CITY OF ALBUQUERQUE

August 28, 2012

Re: Mountain America Credit Union Grading & Drainage Plan, (D20-D010A)
Parcel B, Parcels A, B & C Ventura Plaza **P.E. Stamp: 5/18/12**

C-201

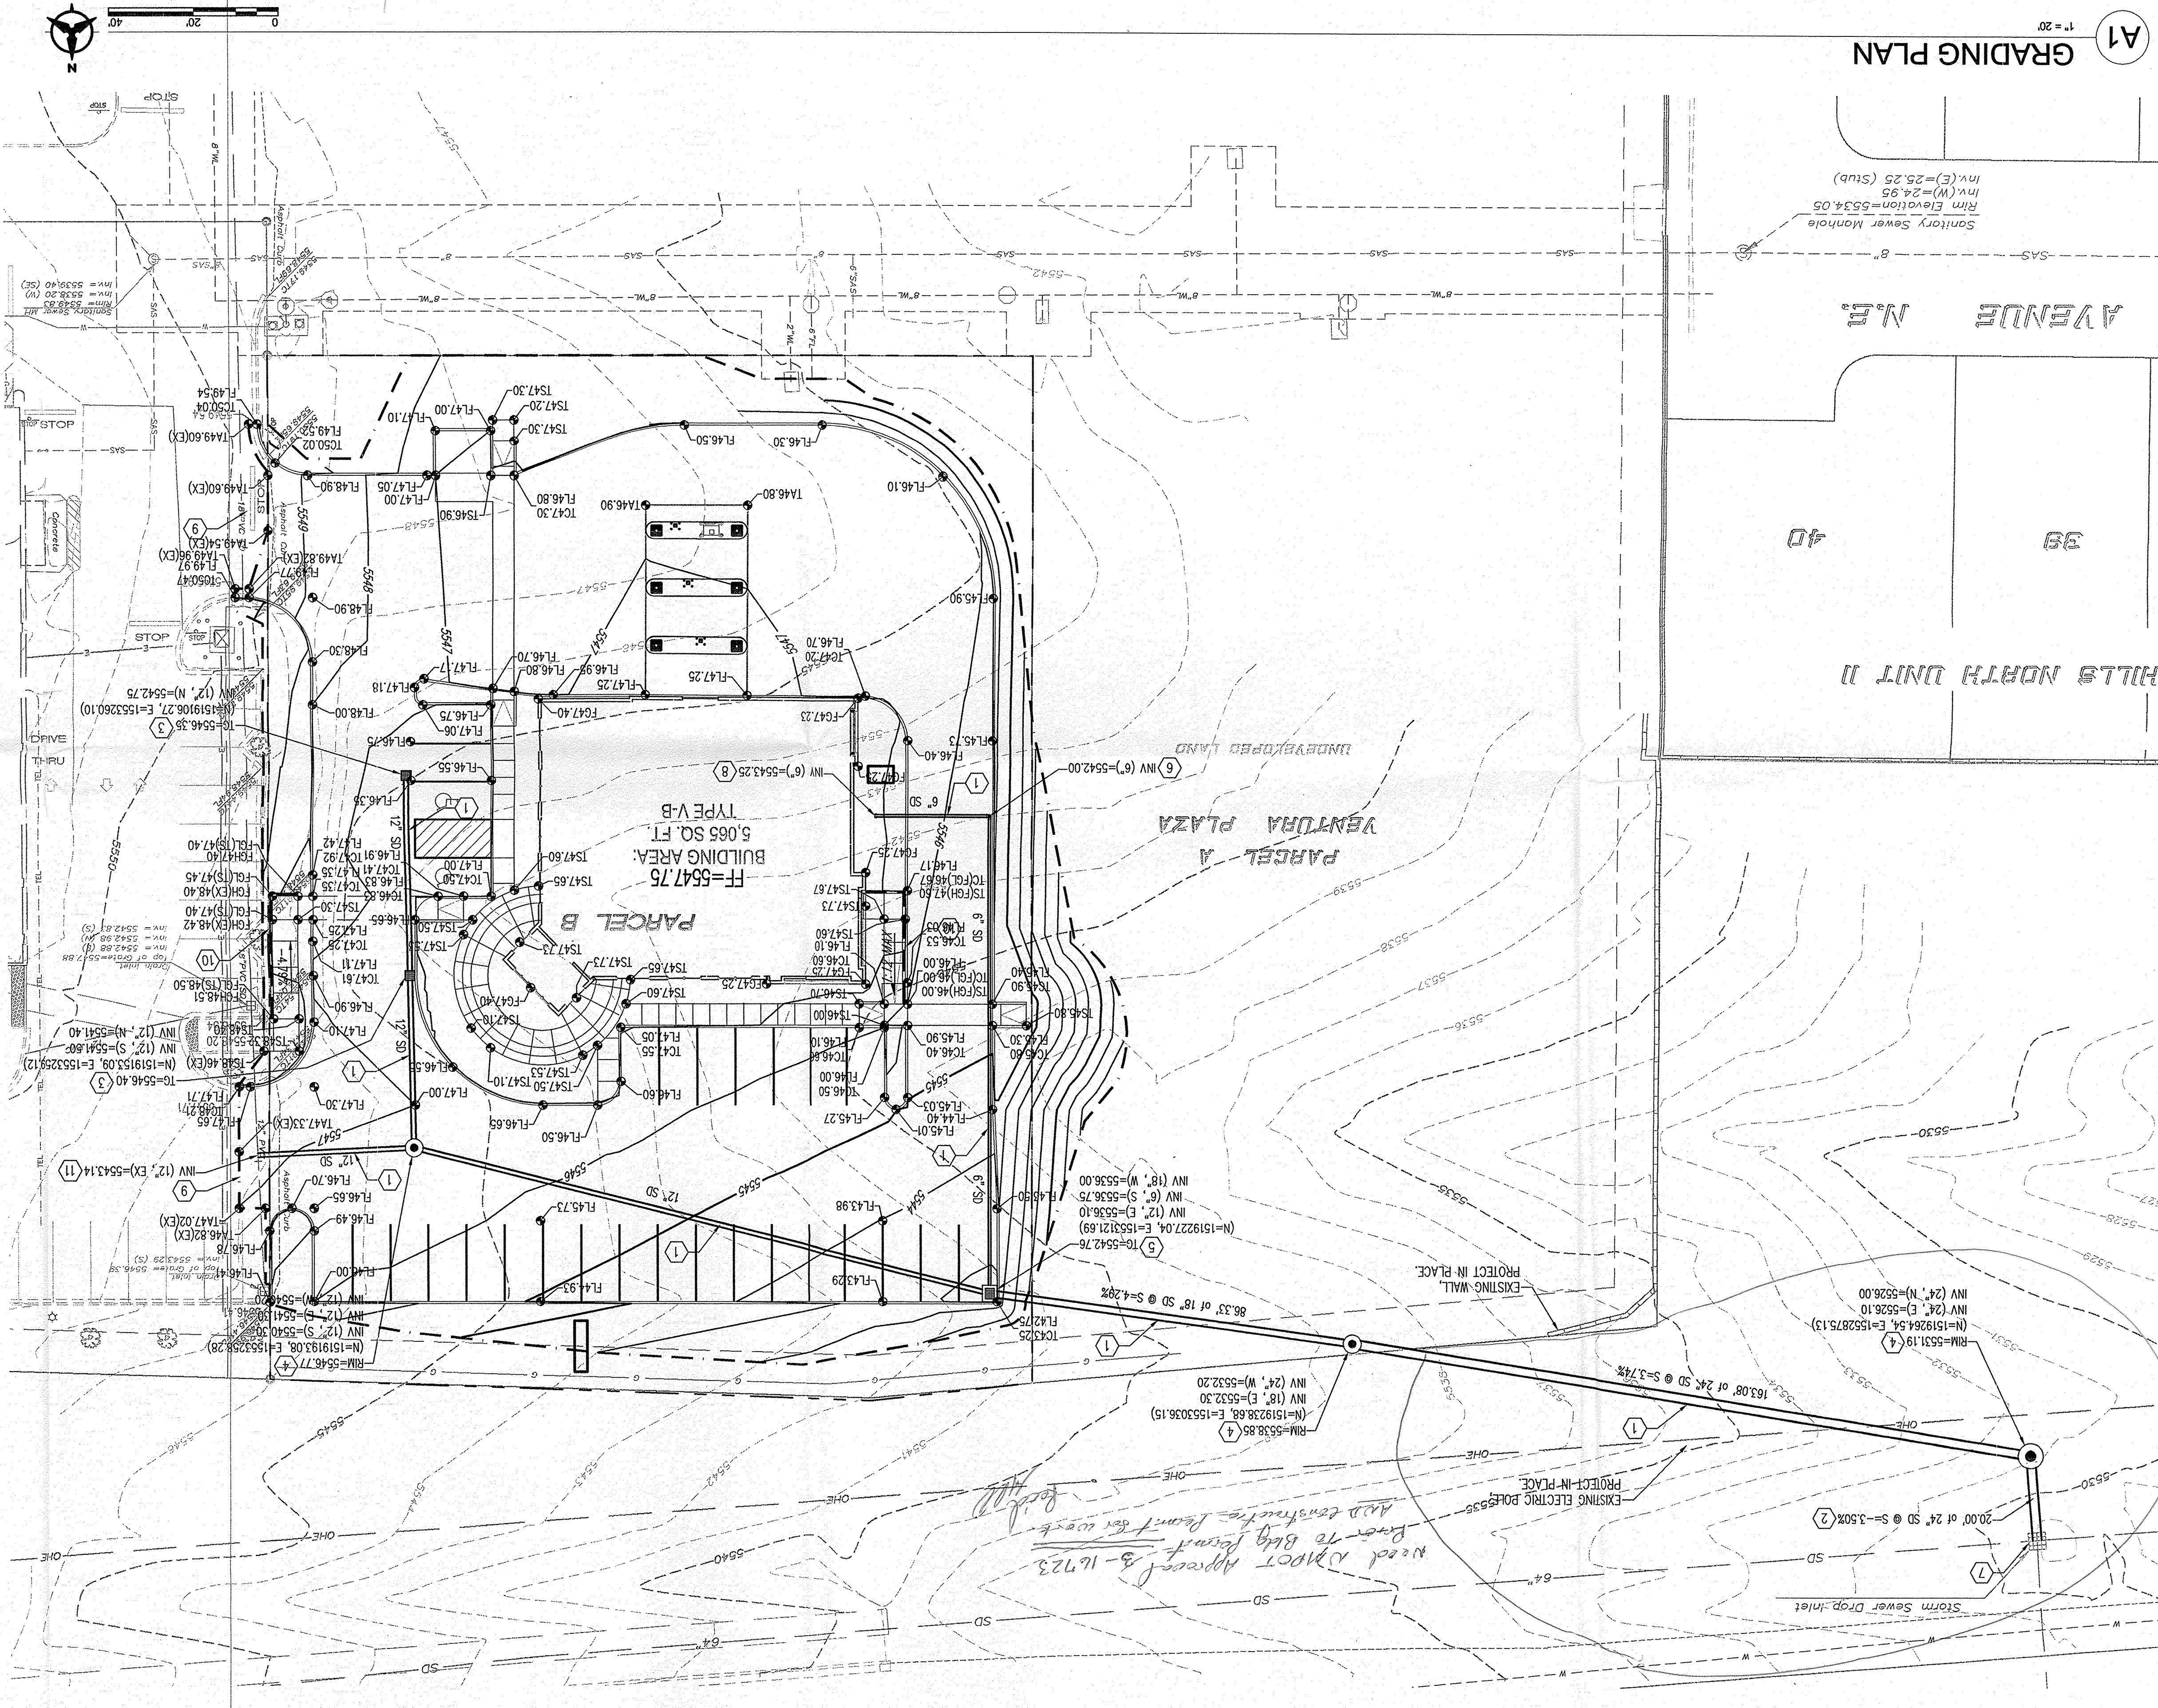
1. This plan lacks a few presentation features required for Grading and Drainage Plans, per the DPM Chapter 22. Please review the criteria, and update future submittals. For this site, I ask that you at least add a location map to the as-built Certification Plan.
2. We will require documentation from NM-DOT of their acceptance of the storm drain connection at the NW corner of the site, authorized under NM-DOT Permit # 3-16723.
